Please ask for: Nicola Moore
Email: nicola.moore@arun.gov.uk
Telephone: Ext 37944
Our Ref: BE/46/21/PL
Your Ref:
Date: 7th April 2021

Application for Planning Permission

Development: Side and rear extension and divide into 2 No. 2 bed properties. This application is within CIL Zone 4 and is CIL liable as new dwelling.
Location: 1 Sunningdale Gardens Bersted PO22 9LE

Proposed Extension & Conversion Into 2 Dwellings Planning
Date March 2021
Scale 1:200 1:1250

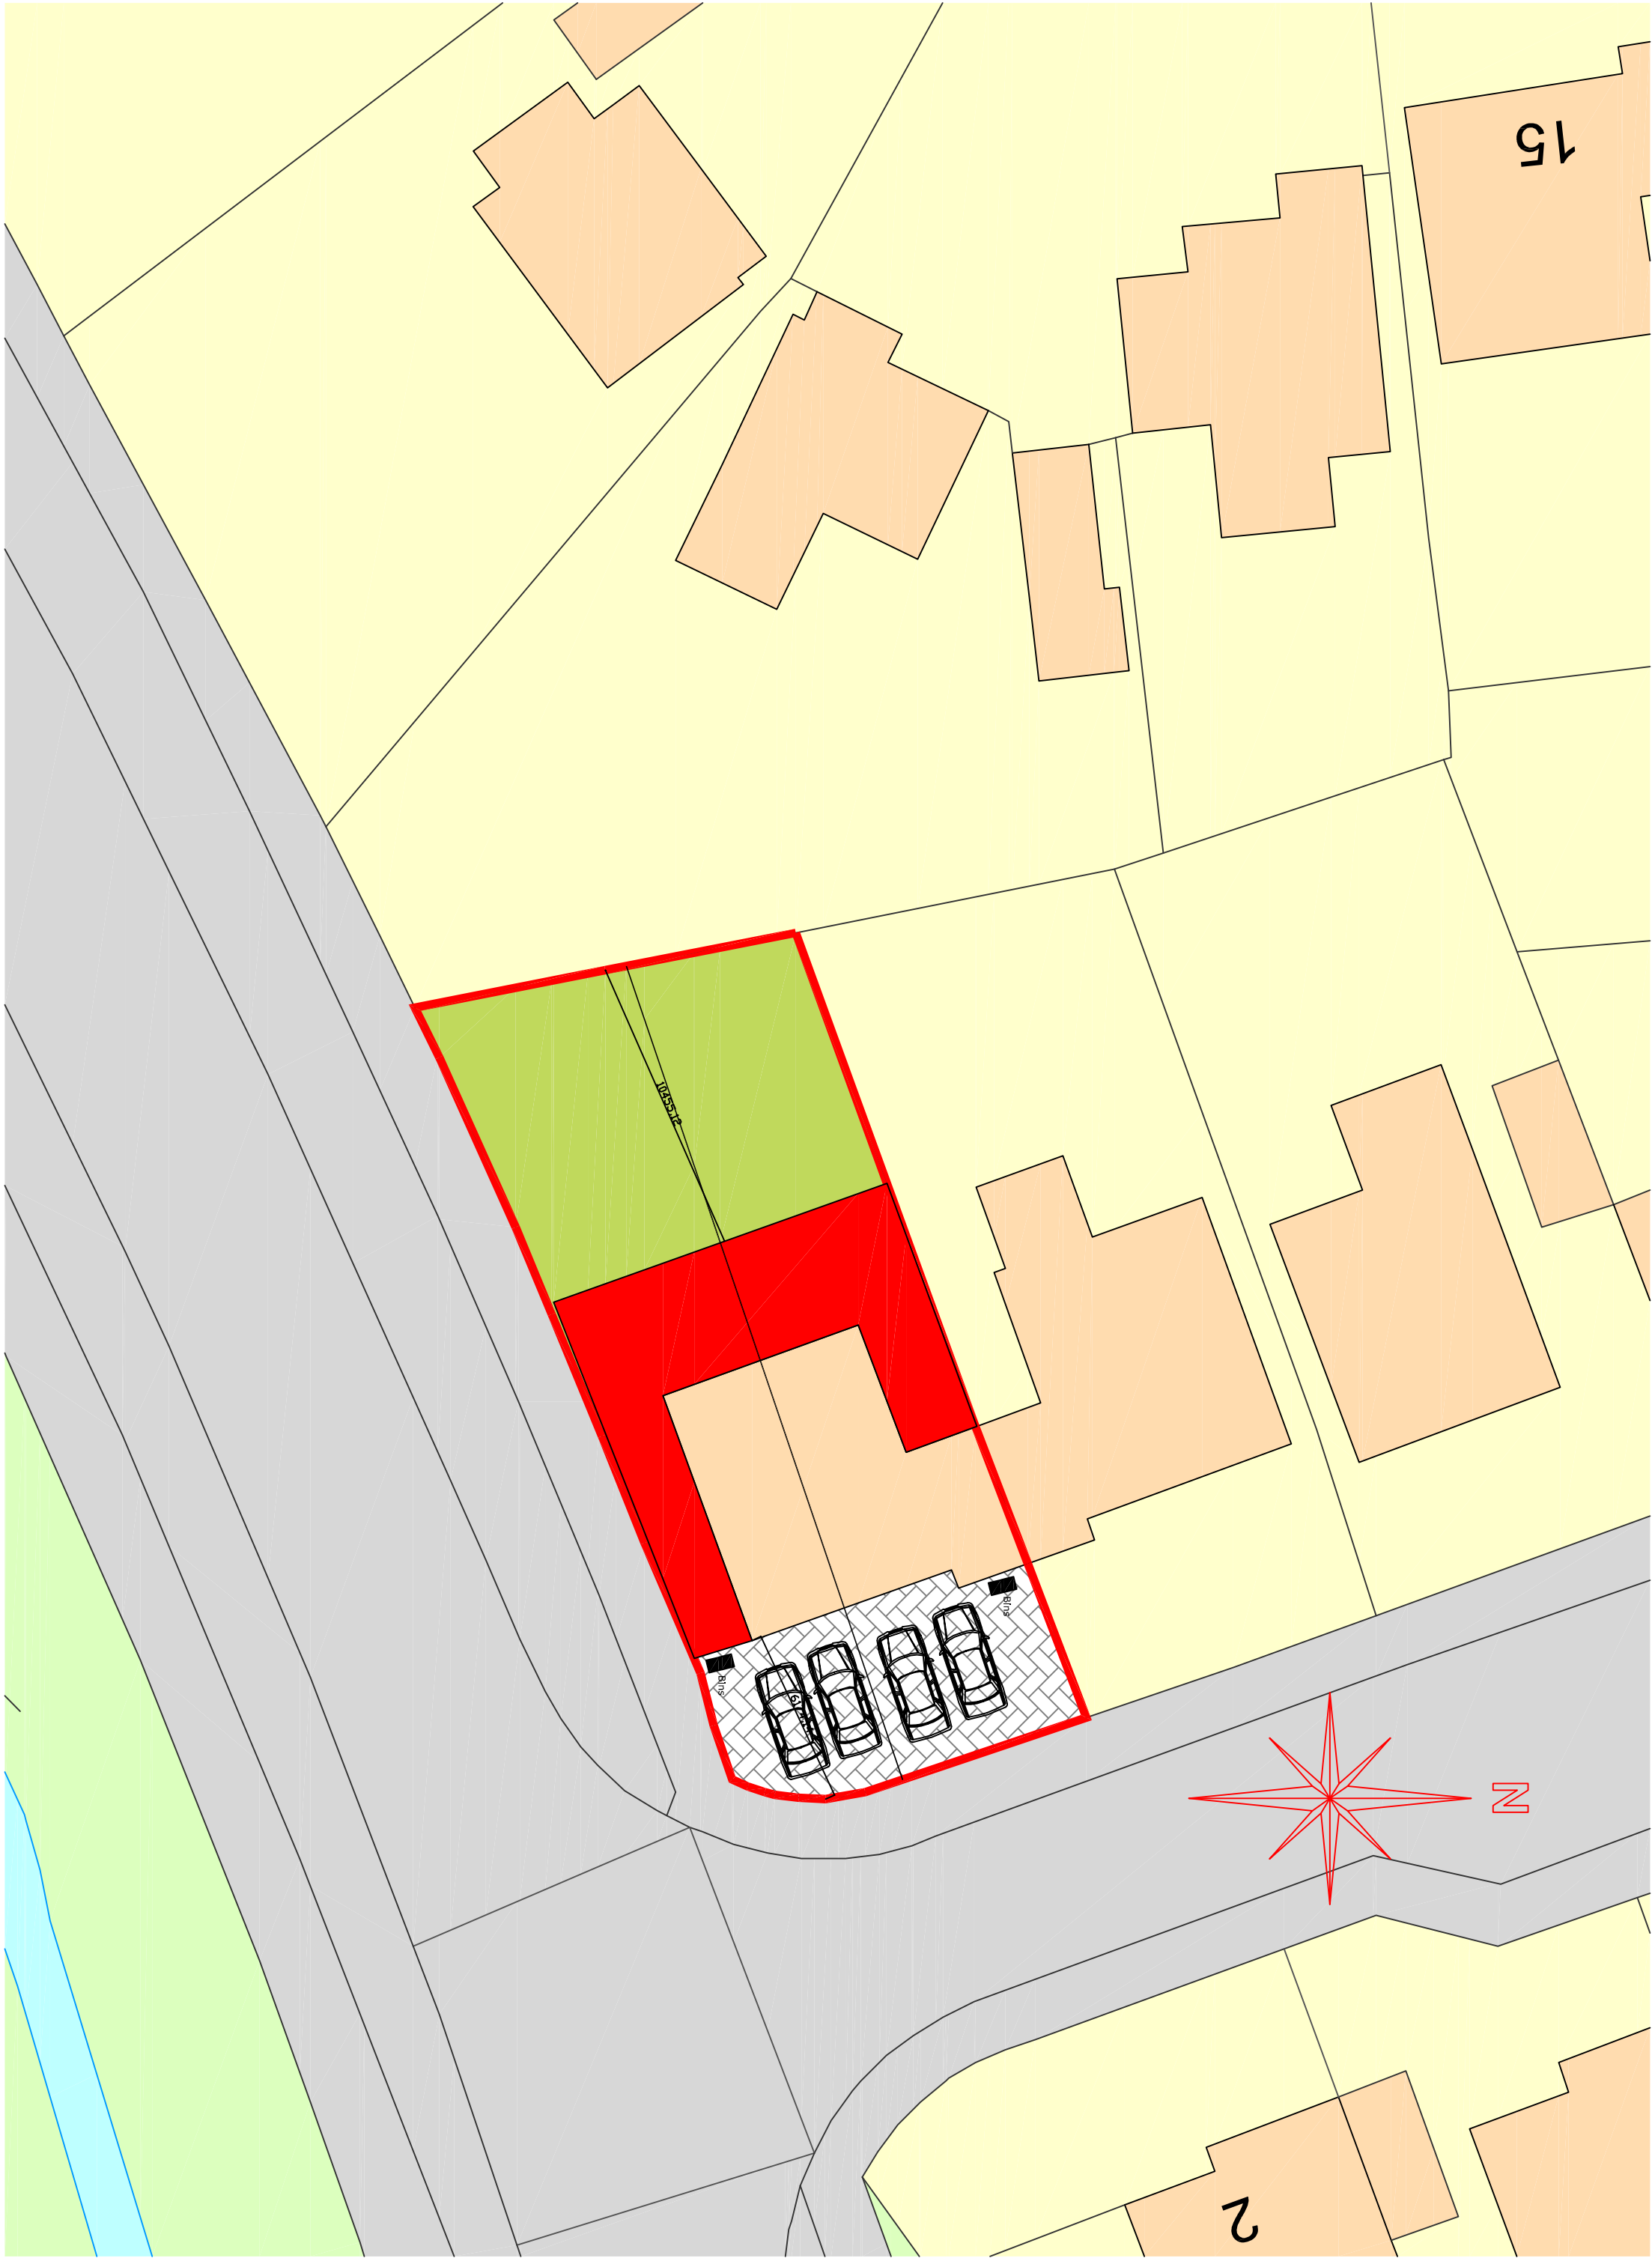
Block Plan

The measurements from the proposed extension to boundaries are required. Please amend accordingly and re submit.

Please amend the site plan to include the waste & storage collection, as mention in Section 14 of the application form.
